Merle Ash  
Land Technologies, Inc.  
18820 3<sup>rd</sup> Avnue NE  
Arlington, WA 98223

Re: 163 RV – *Technical Review 1*  
PA 23016

After preliminary review of the above referenced proposal, the following comments have been prepared:

EXTERIOR ELEVATIONS
 TITLE
 PROJECT ARCHITECT
 DRAWN BY
 CHECKED BY
 PROJECT NO.
17 DECEMBER 2023
 TASK
SEPA SUBMITTAL
 TITLE

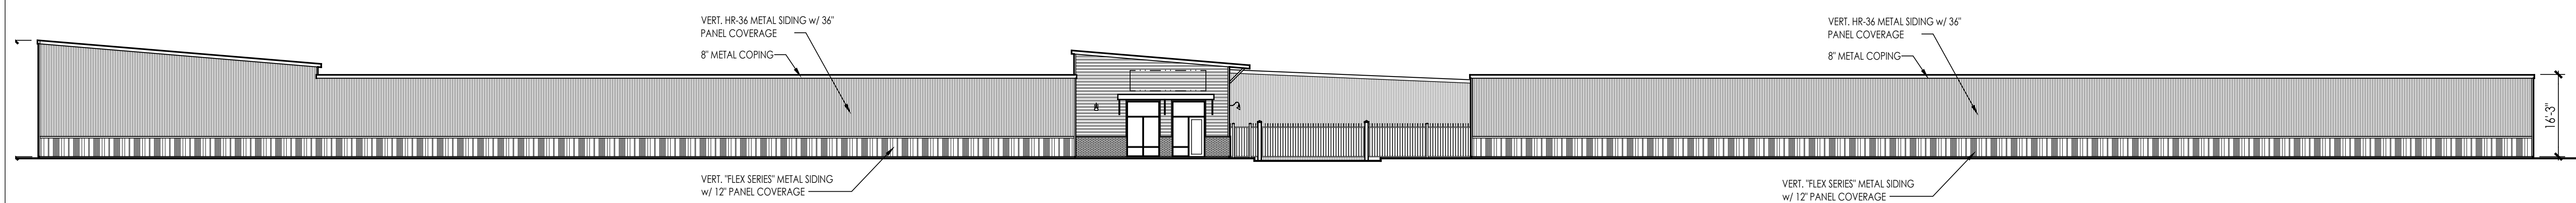
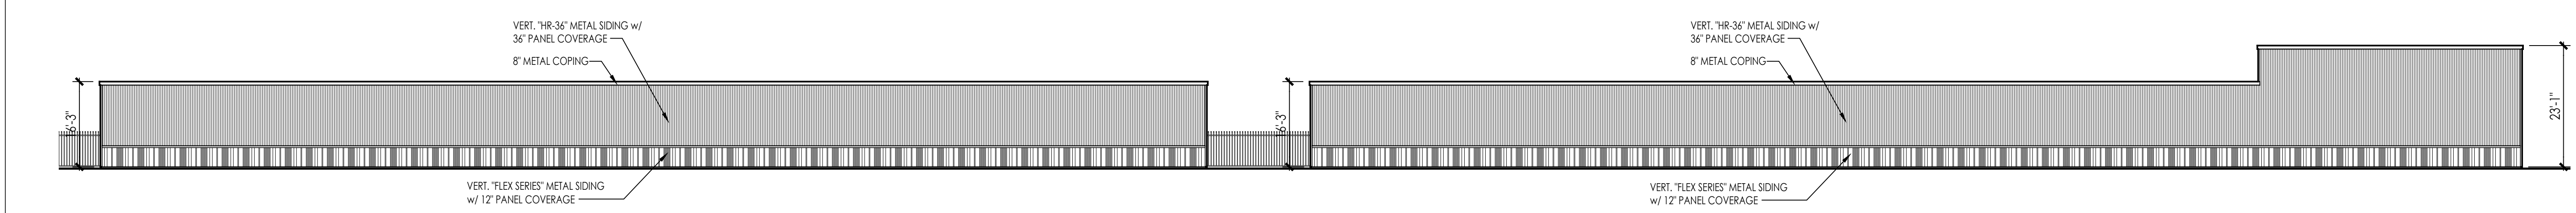
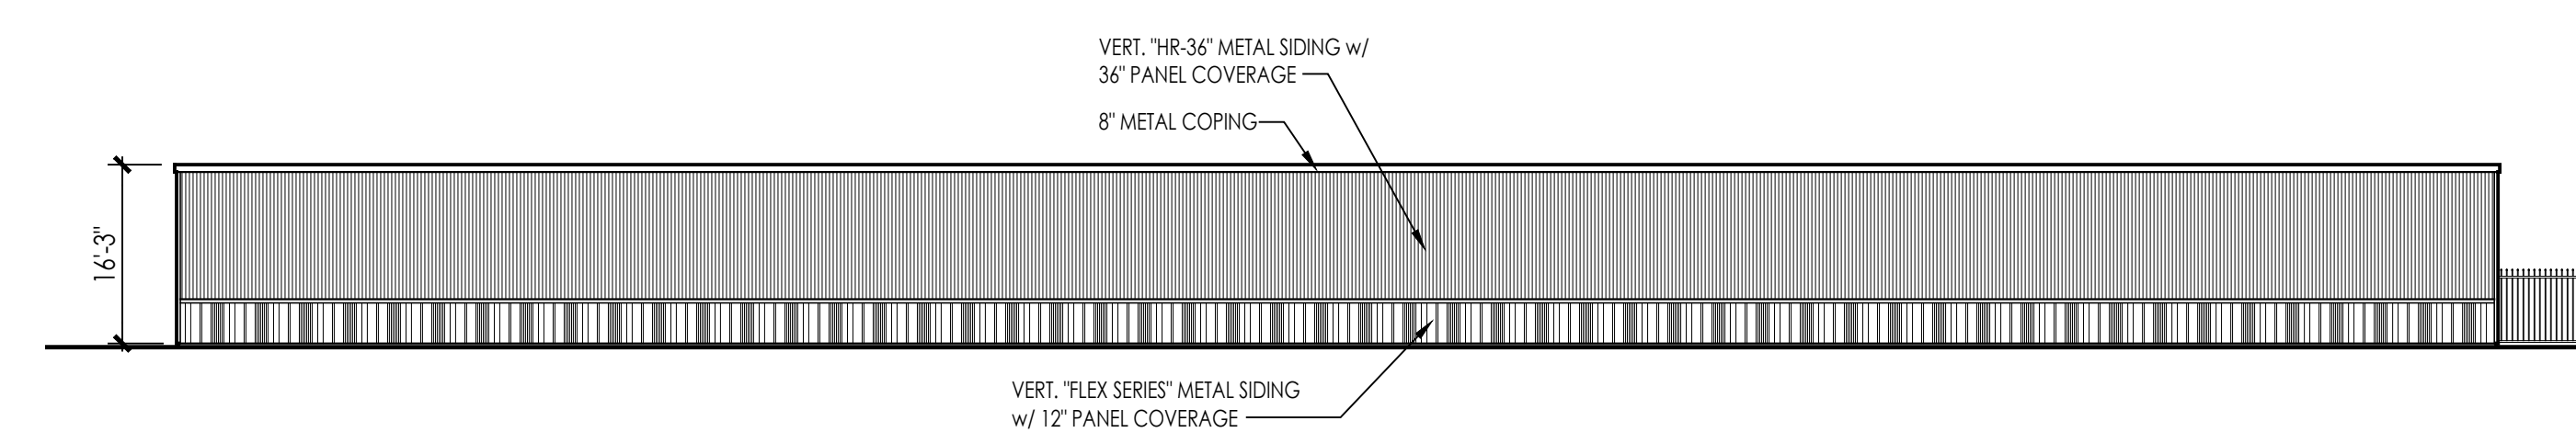
5. Prior to issuing building permits, the applicant shall be required to demonstrate compliance with the applicable building design provisions outlined in [MMC 22C.020.245](#) and [MMC 22C.170.040](#). Design review will be conducted at the time of building permit submittal. Color elevation drawings for all structures shall be required to be submitted with the building permit application.

Additionally, please provide a detail of the proposed wash station, as this appears to be visible from the entryway.

**CIVIL SITE PLAN**

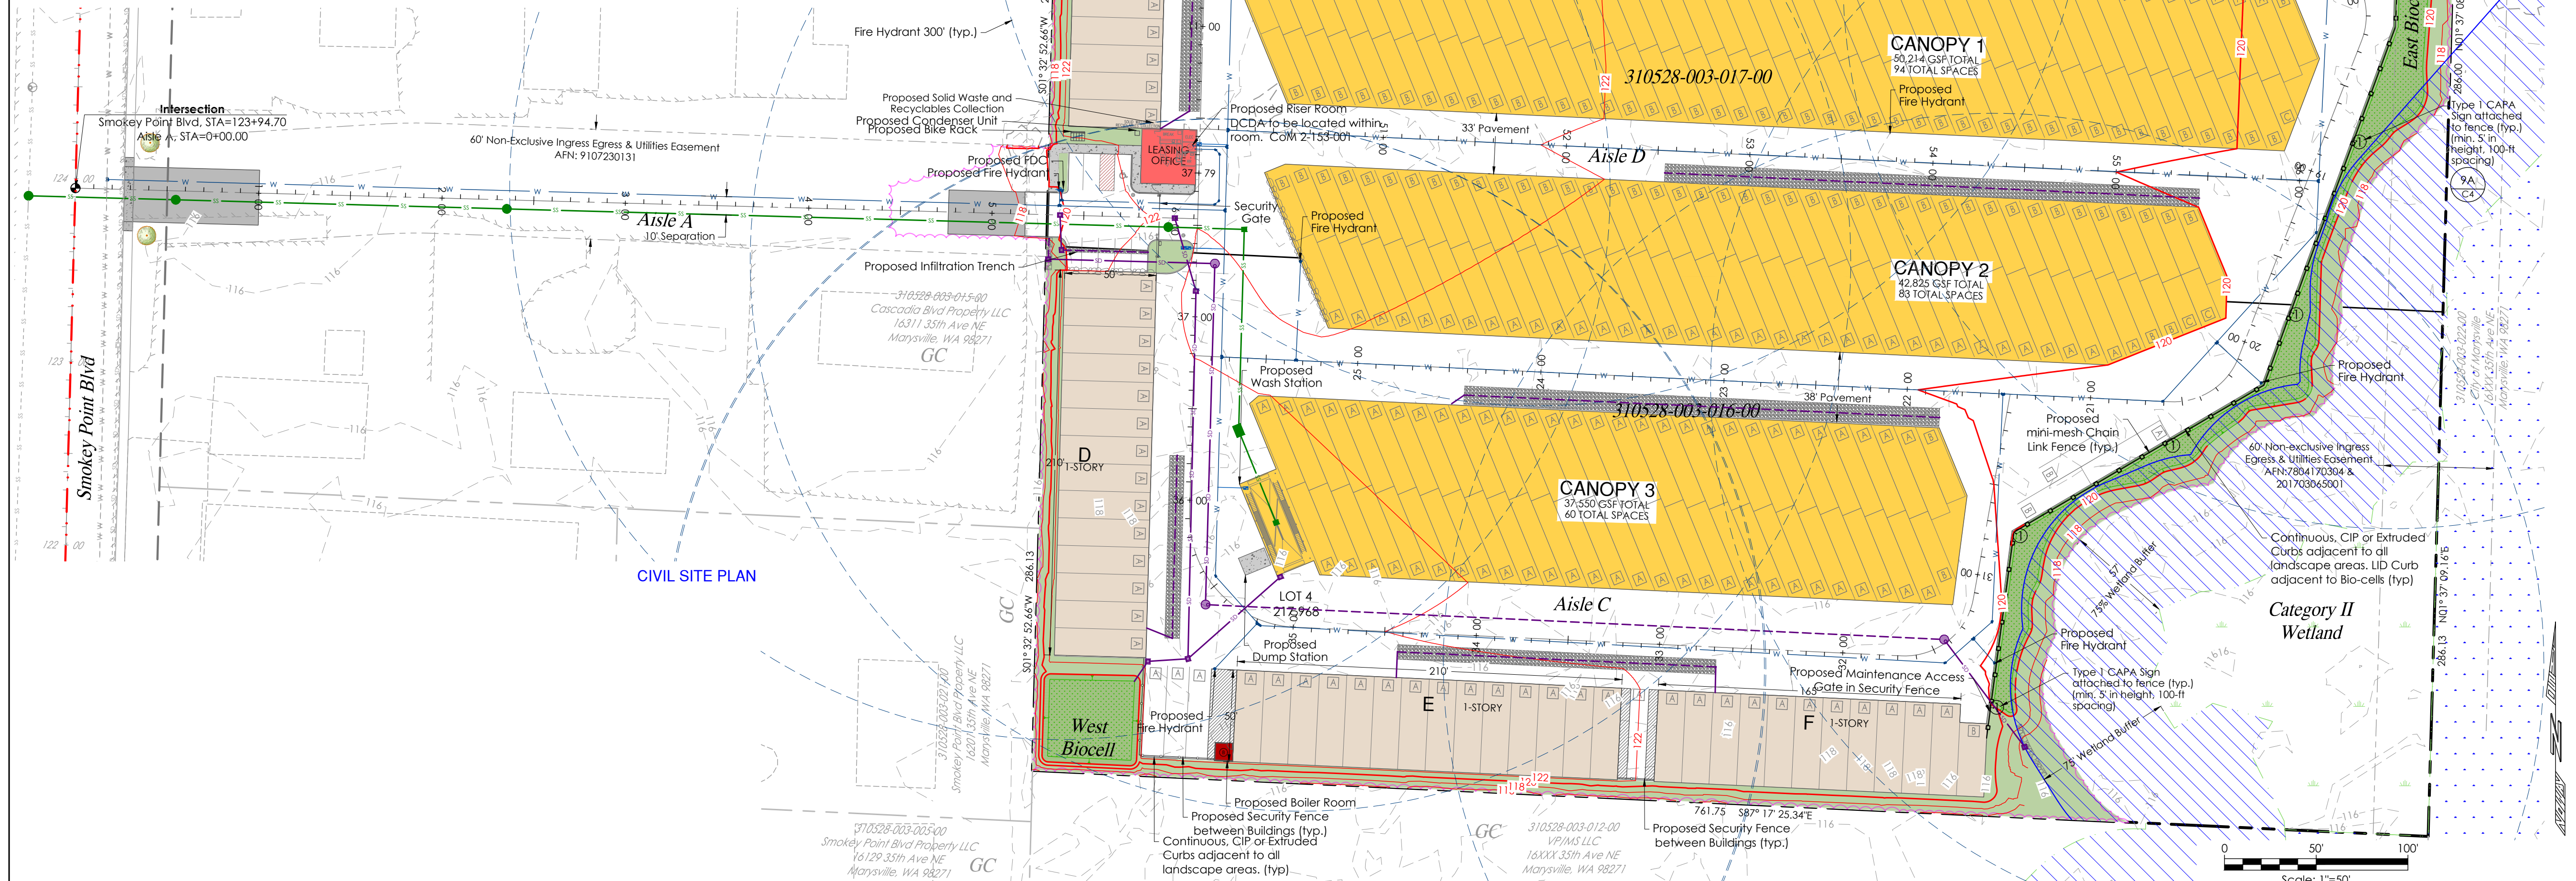
6. The site plan shall be amended, as follows:
  - a. A minimum 5 foot raised concrete pedestrian path shall be provided from the Leasing Office to Smokey Point Boulevard.
  - b. A minimum 26 foot wide paved access shall be provided from the development site to Smokey Point Boulevard.
  - c. Provide a detail of the proposed fencing on the site and civil plans. Fencing is required to be low-maintenance material and articulation at intervals no greater than 20 feet.

- d. Security fencing is proposed adjacent to the critical areas buffer, therefore, the split rail fence can be eliminated. NGPA Fencing shall be required to be placed on the security fencing and spaced 1 per 100 feet.

- e. Pursuant to [MMC 22C.170.040\(h\)\(i\)\(B\)](#), the area devoted to outdoor storage is less than 50 percent of the footprint of the storage building(s). Provide this calculation on the site plan.

- f. Provide the location for solid waste and recyclables collection. Contact Kristy Beedle, Solid Waste Supervisor, 360.36.8152 [kbeedle@marysvillewa.gov](mailto:kbeedle@marysvillewa.gov), for enclosure size and design requirements.

SEWER AND WATER OVERVIEW PLAN

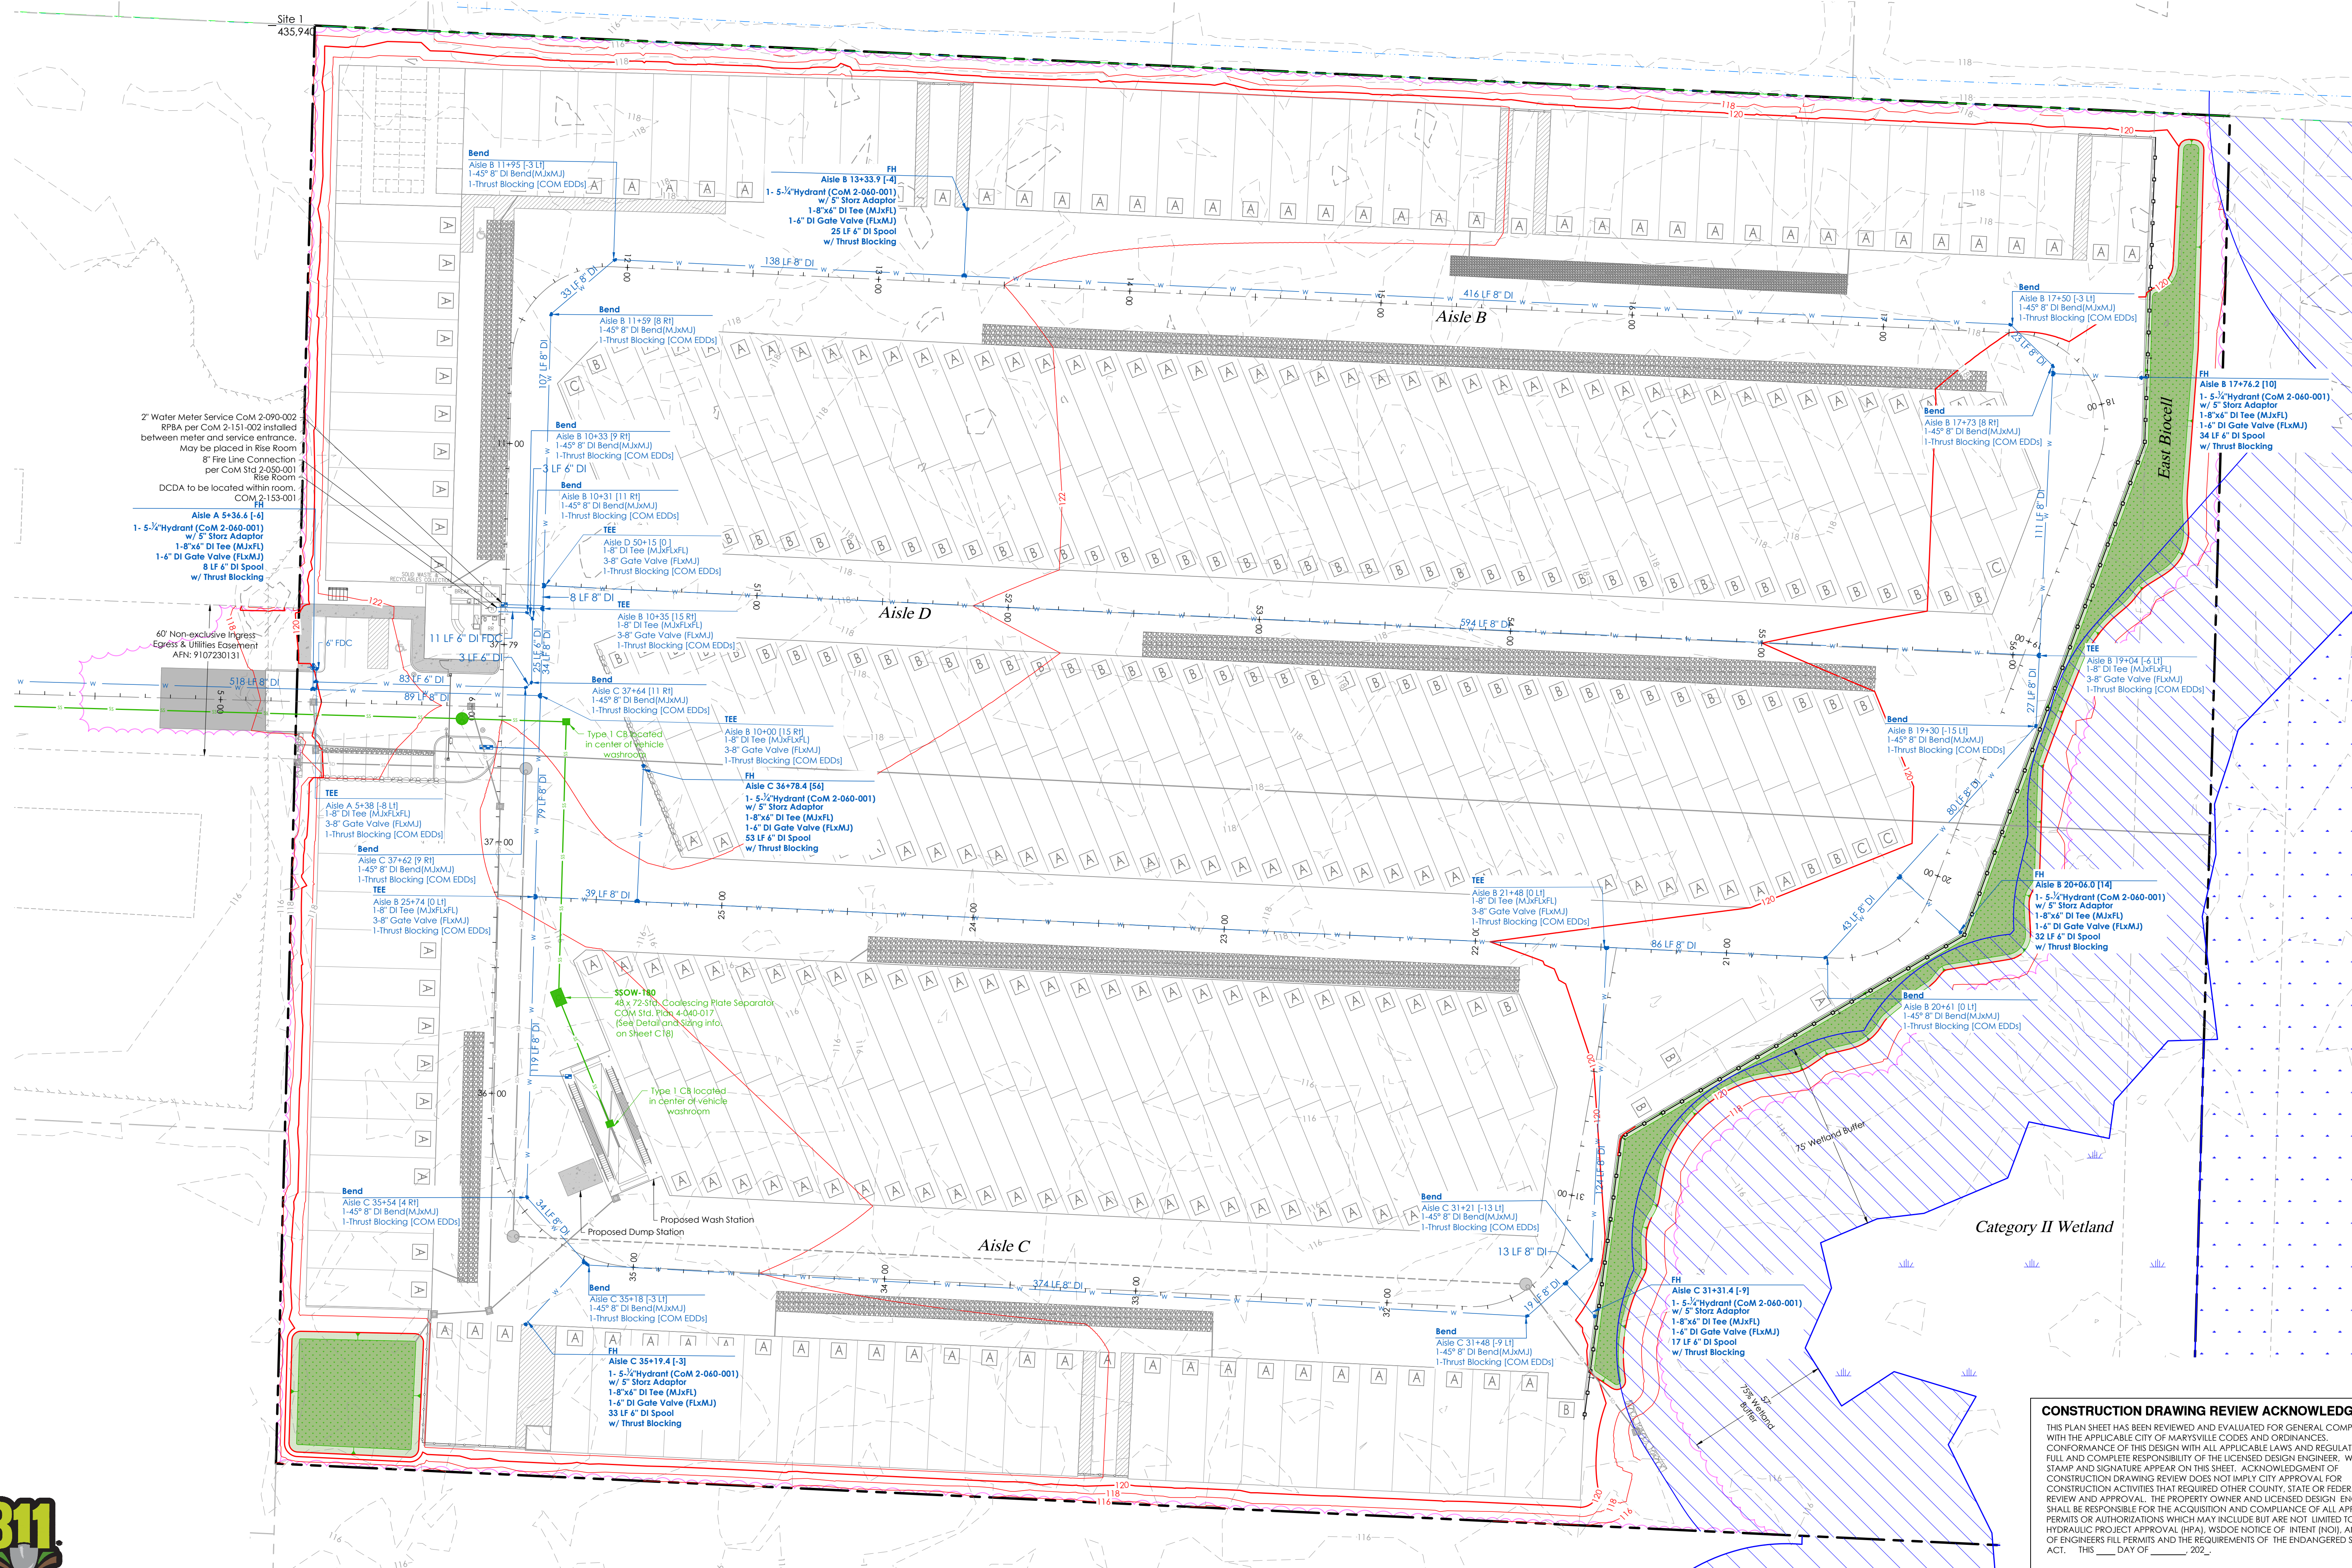
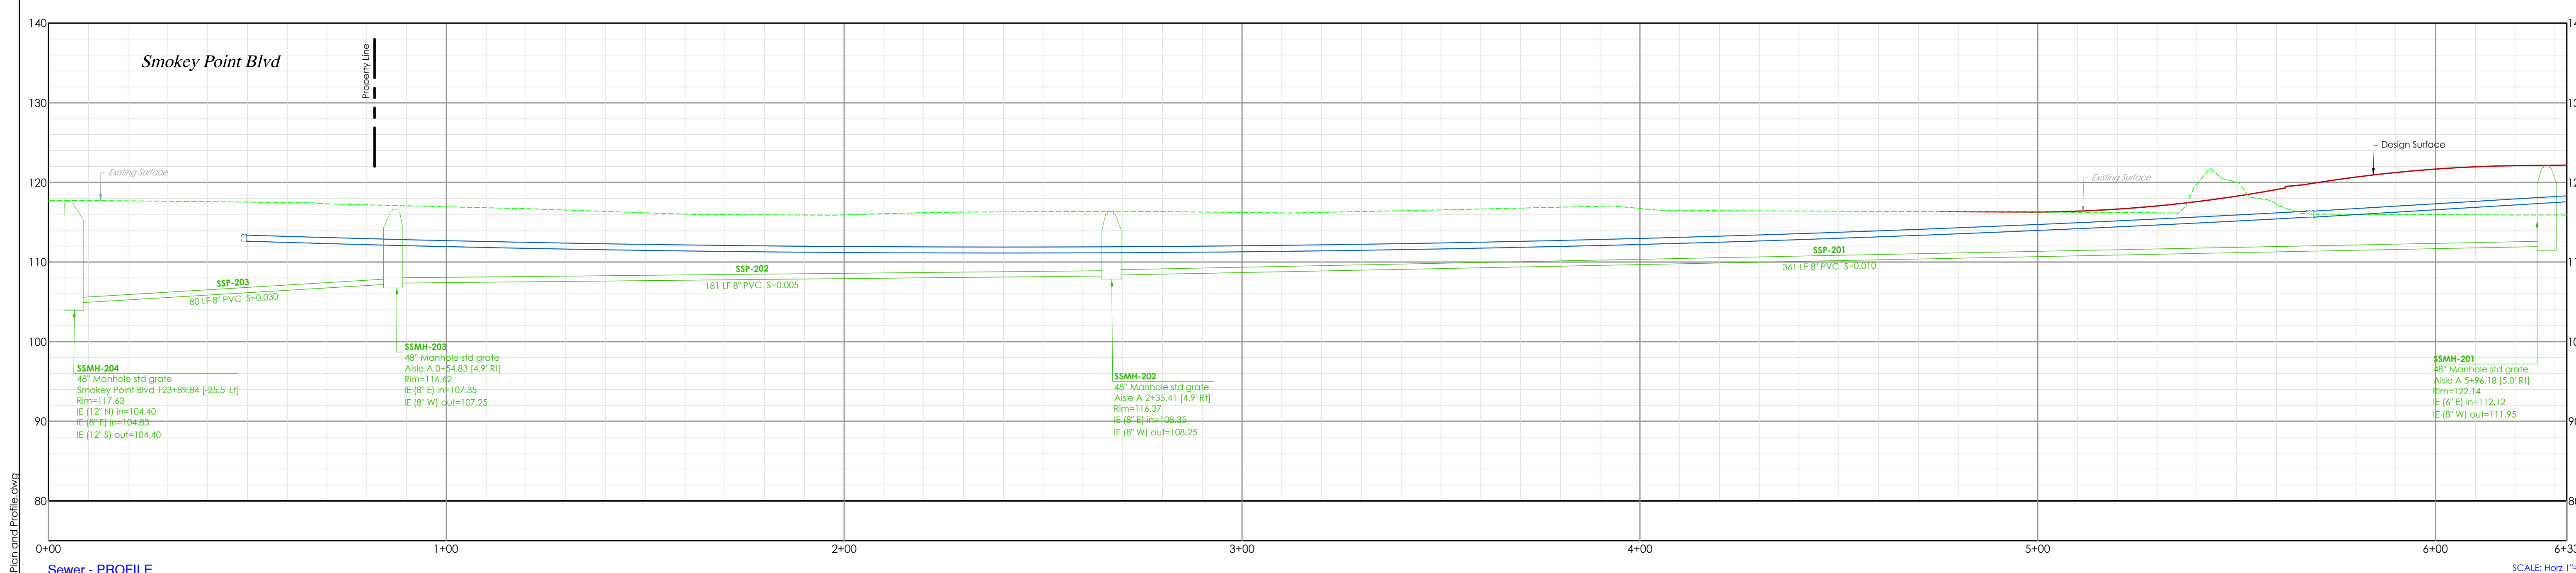
45. The water plan shows an 8" DI water main extension to the site with one hydrant at the entrance into the storage yard. The plans do not show the water line loop or hydrants within the storage yard.

48. An approved water main extension is required within the site for this development (IFC 507). Fire hydrants will be required in approved locations, with maximum spacing of 300 feet apart along approved access roads. Hydrants shall comply with city Water Design Standard 2-060 Hydrants, including 5" Storz fittings, with blue reflective hydrant markers to be provided in the roadways, located four inches off the centerline on the hydrant side of the road. Fire hydrants with approved water supply must be in service prior to storage yard operation.
